CITY OF ALBUQUERQUE

October 25, 2022

TO: Allen Whitaker, Stantec
FROM: Alan Varela, Planning Department Director
RE: Parking Reduction Request- New Mexico Cancer Center Site Plan Major Amendment

This parking reduction request is associated with a Site Plan-Major Amendment (PR-2022-7588_SI-2022-1658) for a 17,472 square feet (SF) expansion of the NM Cancer Center at 4901 Lang Avenue. The request is currently under review with the Development Review Board (DRB). The first review with the DRB took place September 28, 2022.

Title
DRB SITE PLAN

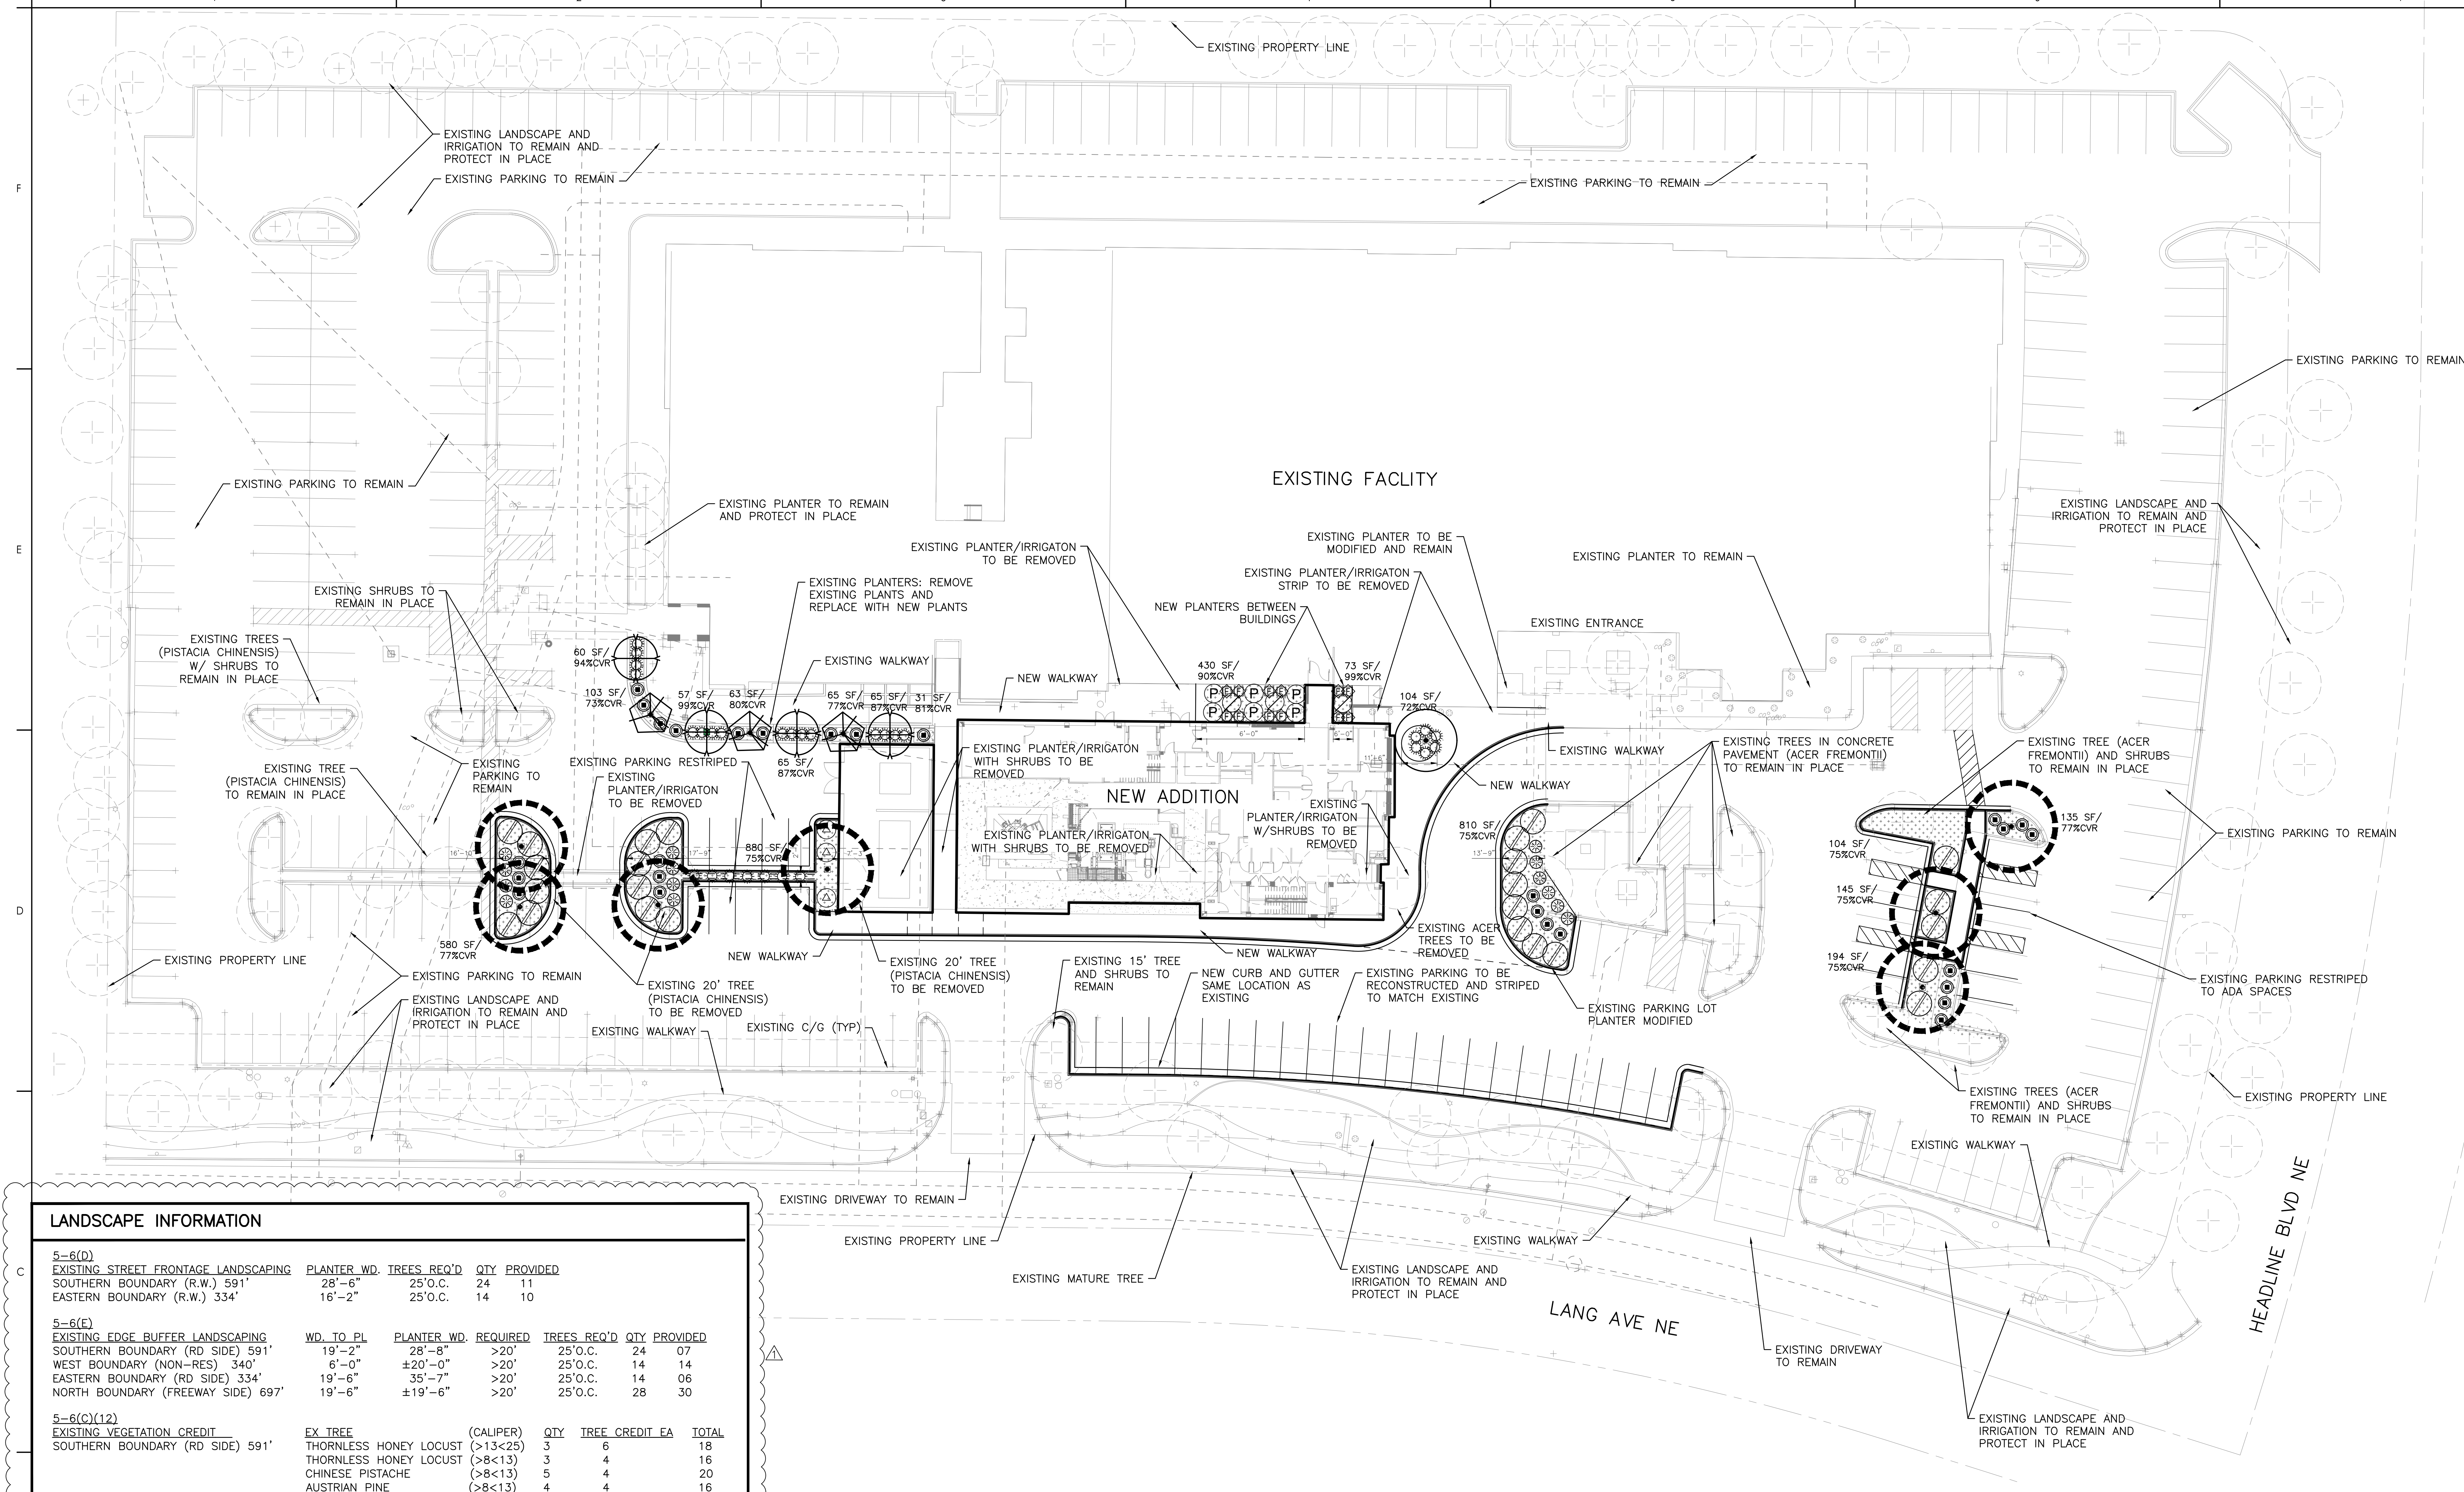
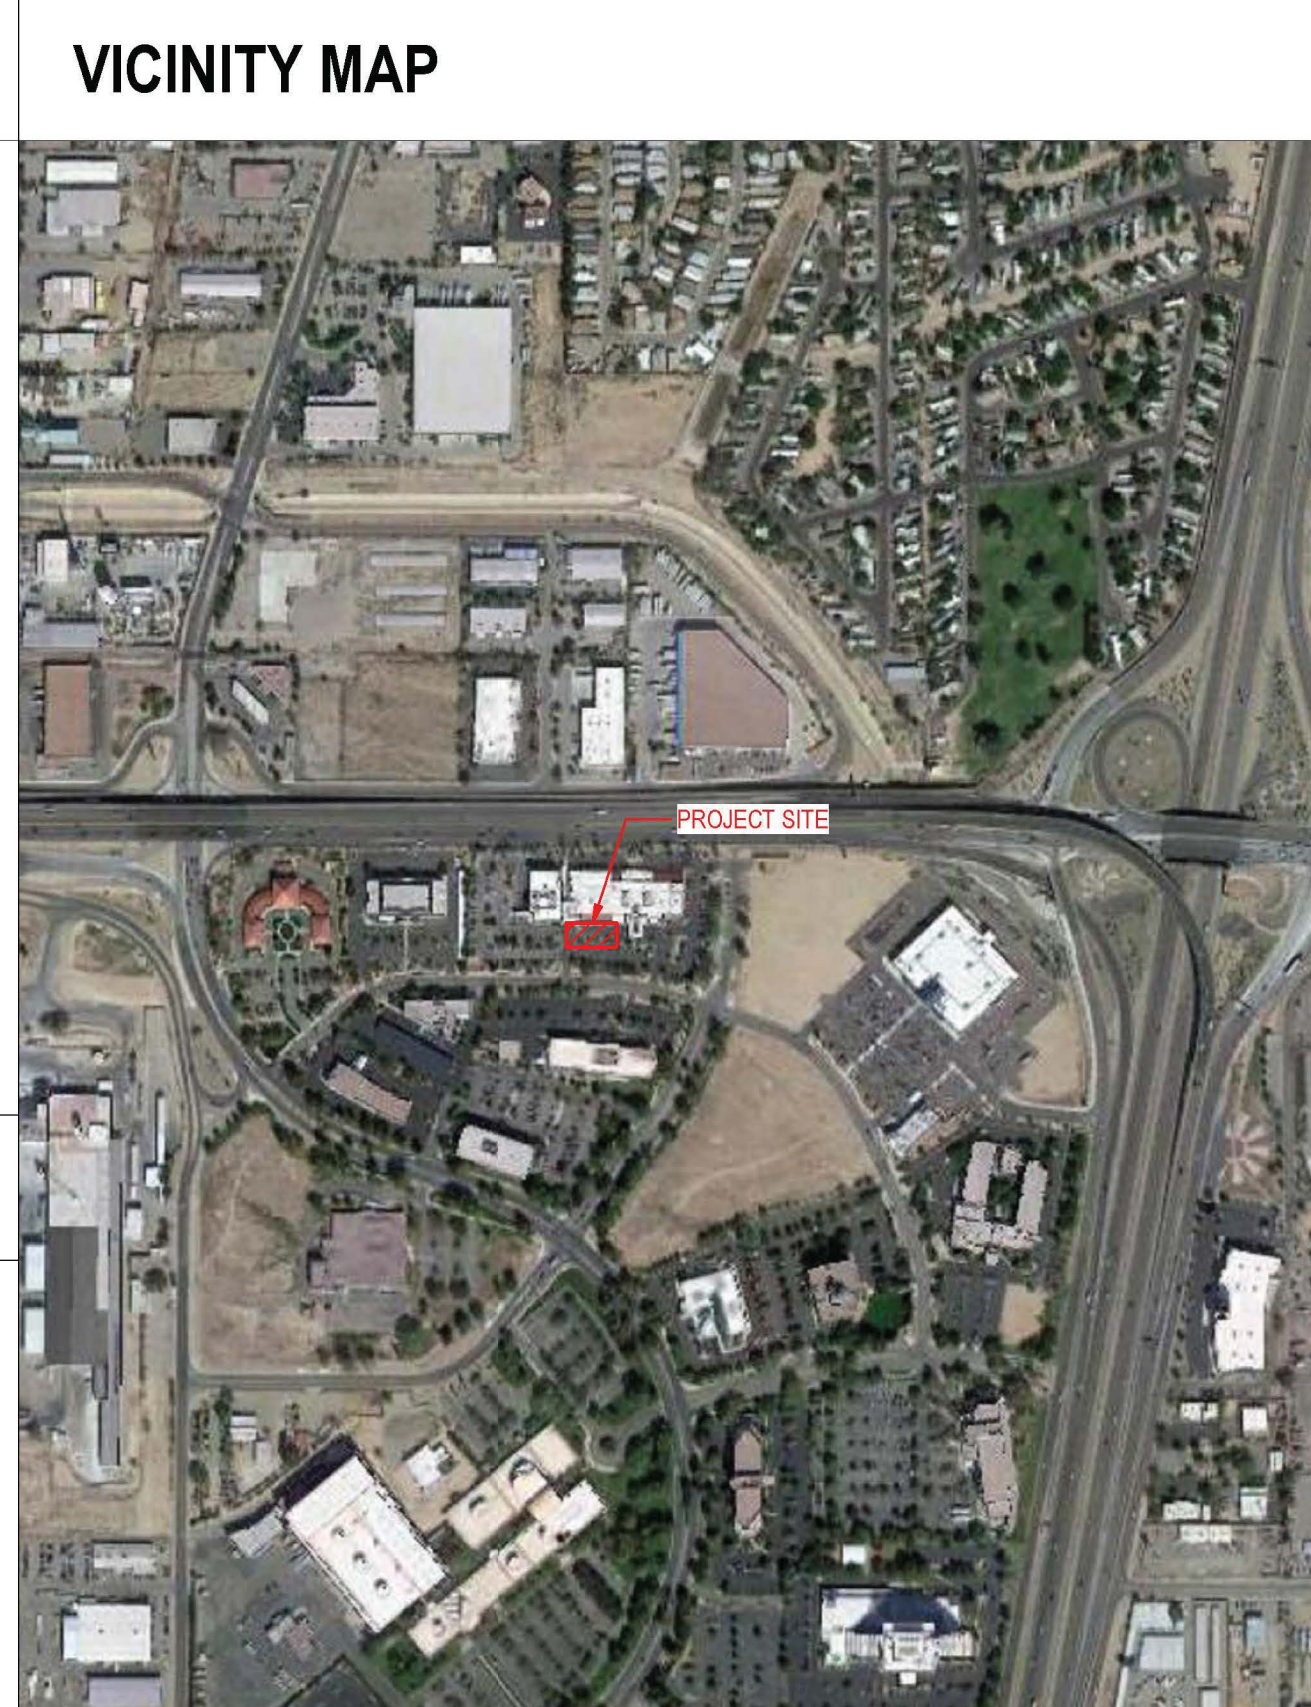
The NM Cancer Center has requested a parking reduction from IDO requirements to result in 332 required spaces with 294 spaces provided on-site and with 38 spaces provided through a shared parking agreement (which will be for 50 spaces) with the Courtyard Marriot hotel. The hotel is approximately 700 feet from the NM Cancer Center, rather than the IDO prescribed maximum distance of 330 feet distance. The NM Cancer Center will renew this parking reduction agreement with the City within five years of Site Plan approval to determine adequacy of parking and if a shared parking agreement with the Courtyard Marriott and/or any other business in the near vicinity should be extended or created.

Based on initial DRB comments that proposed parking did not meet IDO standards, the applicant submitted a Parking Study pursuant to IDO Subsection 14-16-5-5(C)(5)(e), which states that the Planning Director may approve a reduction of parking requirements if the applicant provides a parking needs study prepared by a consultant with expertise in that area and demonstrates that a reduction in the off-street parking requirement will adequately accommodate all anticipated parking demand. The applicant submitted the following information to justify their request for a parking reduction:

- (b) The 2006 NM Cancer Center approved site plan which shows that the required parking for the 79,000 s.f. building was approved for 320 parking spaces. While 349 spaces were constructed, the new expansion will eliminate 55 spaces, resulting in 294 spaces available on the site.

- (d) The new parking spaces requirement requested should be 320 (for the existing building) plus 12 (new expansion space) for a total of 332 parking spaces.

In the October 21, 2022 submittal (see attachment), the applicant explains the rationale for the parking calculation rates requested. The calculations result in 332 spaces of required off-street parking; 294 spaces will be provided on-site and at least 38 spaces will be provided at the Marriot Hotel at 5151 Journal Center Blvd. The shared parking agreement with Titan Development will be recorded with Bernalillo County. The Planning Director approves this parking arrangement for the NM Cancer Center and further directs that the NM Cancer Center will renew the Parking Arrangement within 5 years of the date of the DRB Site Plan Amendment approval to assess the need for an extension of the existing agreement or for any new shared parking agreements.
